PLAN REVIEW SHEET

Petition #: RZP 2022-099

Address: 1501 E. Independence Blvd.

Request: MUDD-O

**RZ-1**

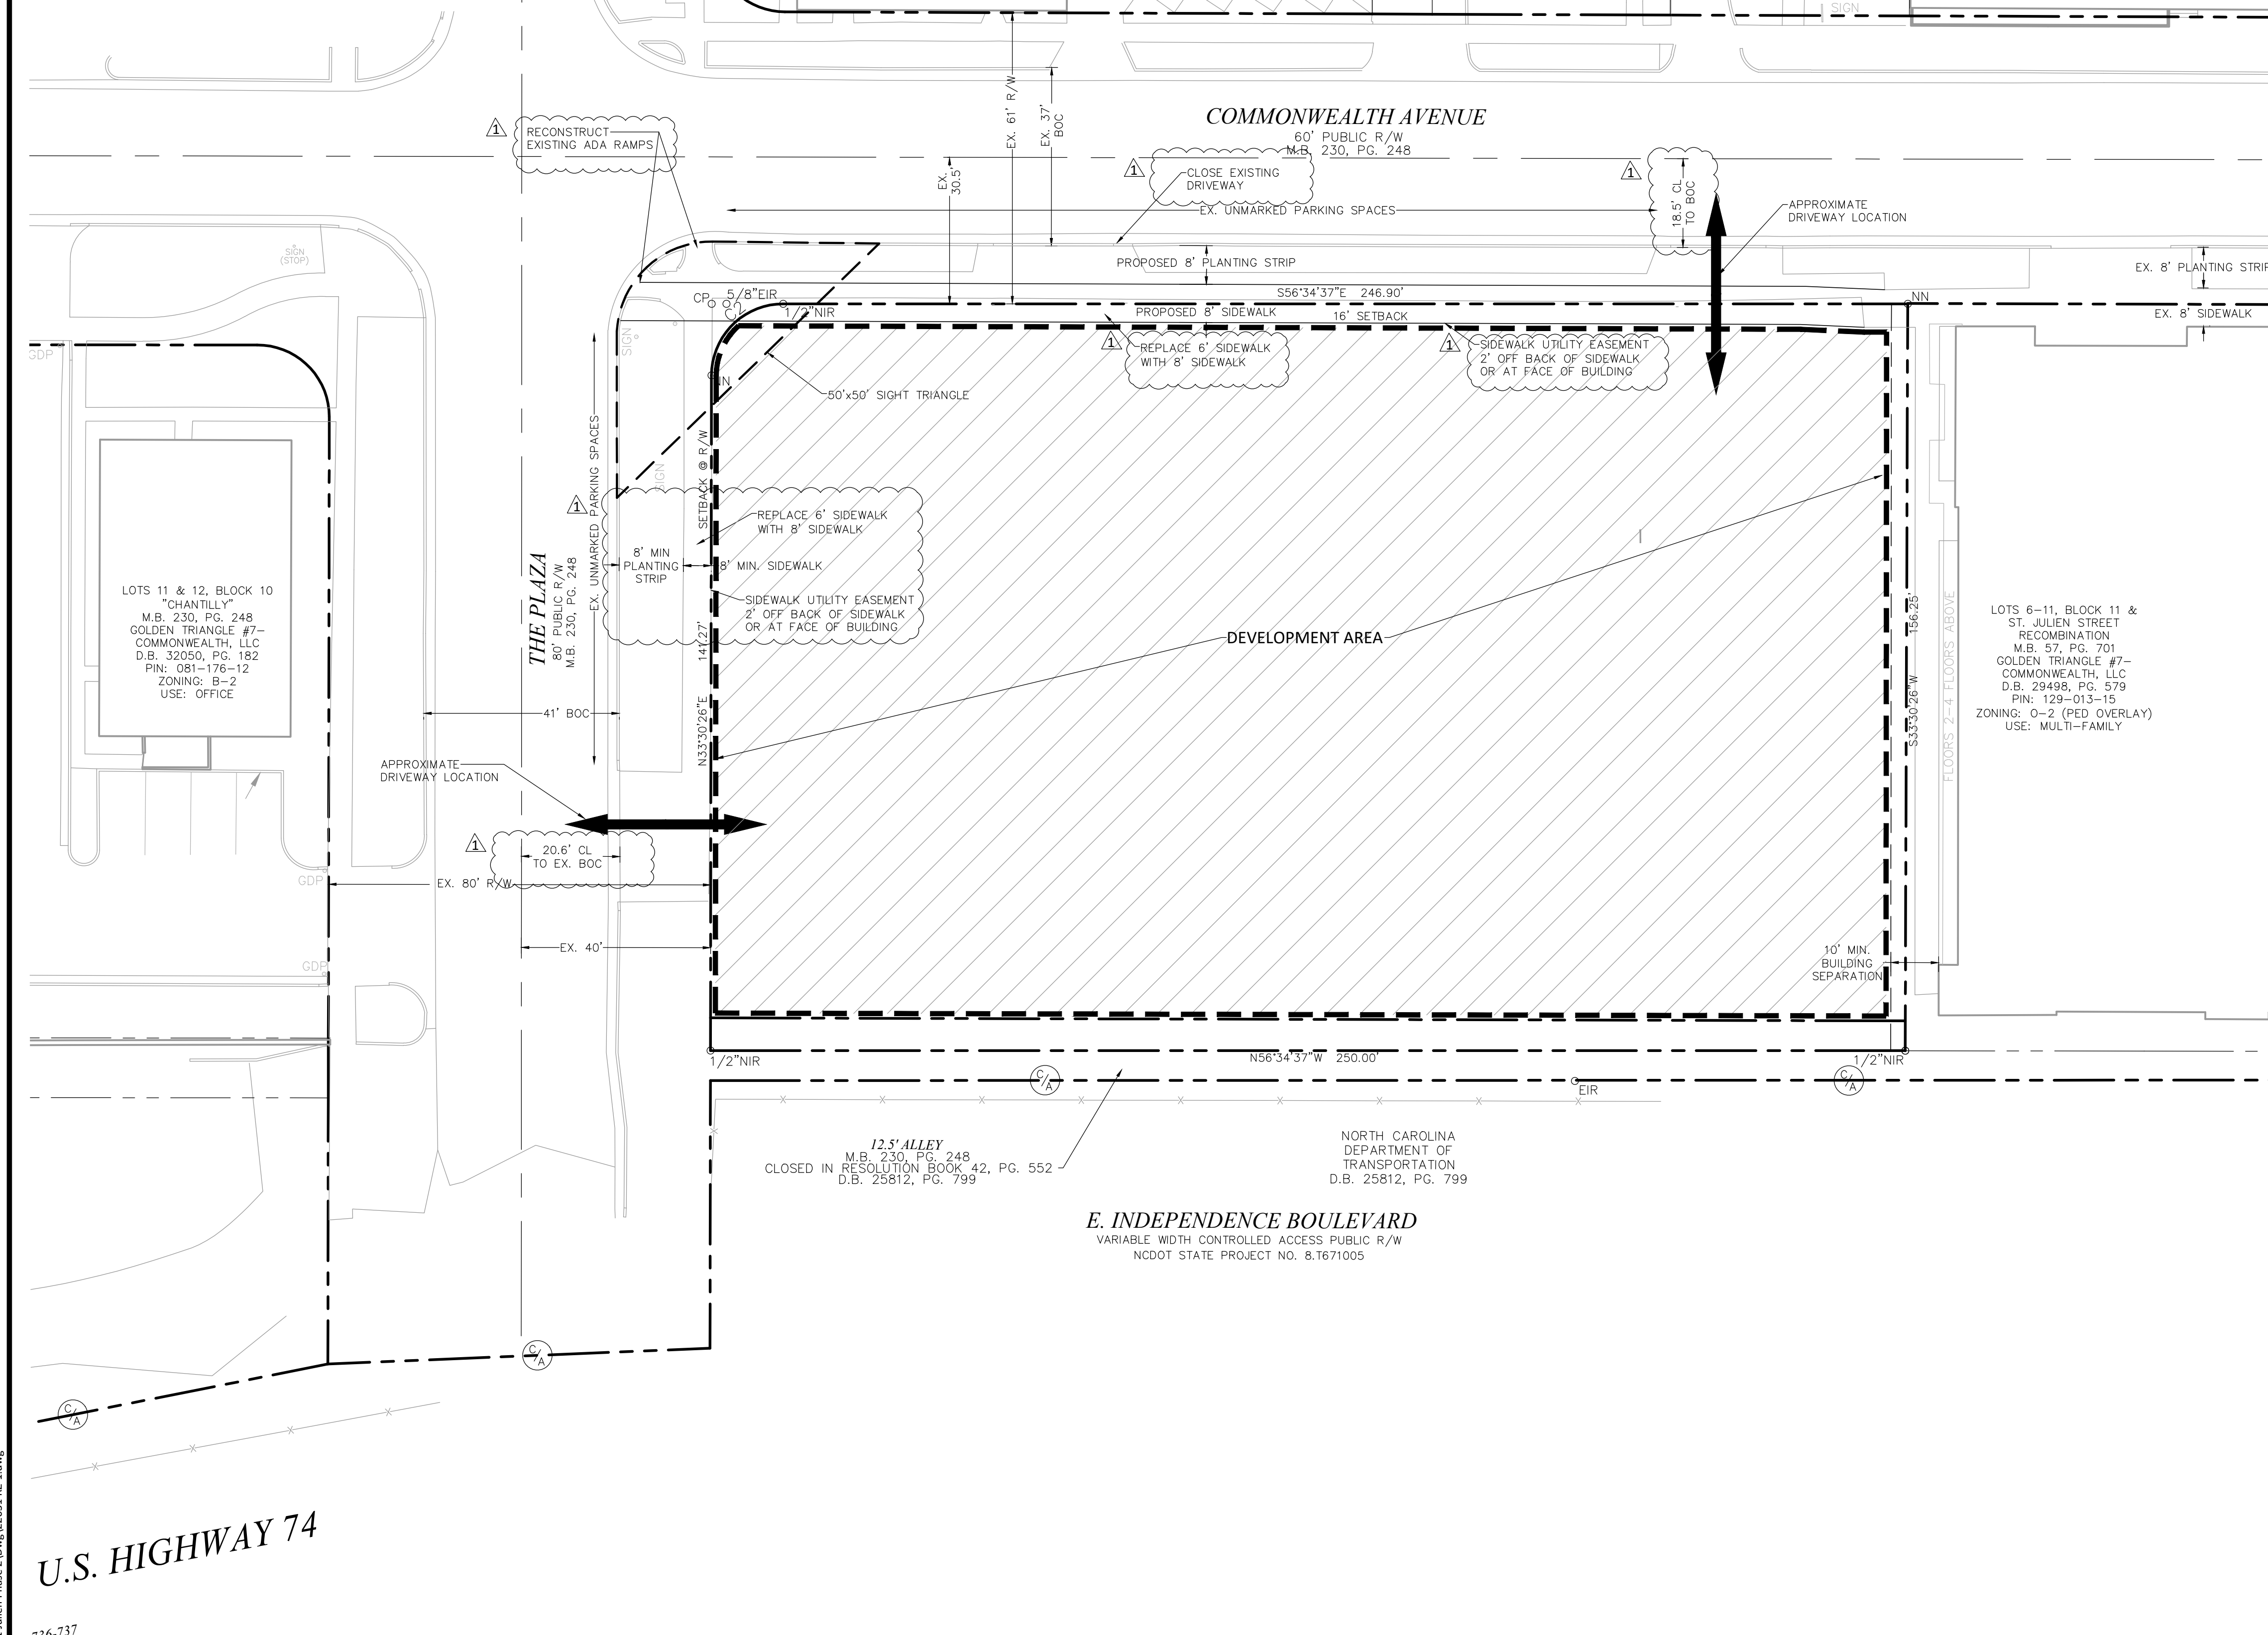
The site is adjacent to the LYNX Silver Line light rail transit corridor. The minimum required right of way for the light rail corridor is 70 feet (35 feet measured from the centerline of the tracks). CATS is requesting a conditional note to include the reservation of the light rail corridor, if needed. Image 1 is the proposed alignment as shown on Charlotte Explorer. CATS will continue to work with the developer through the Land Development plan review process.
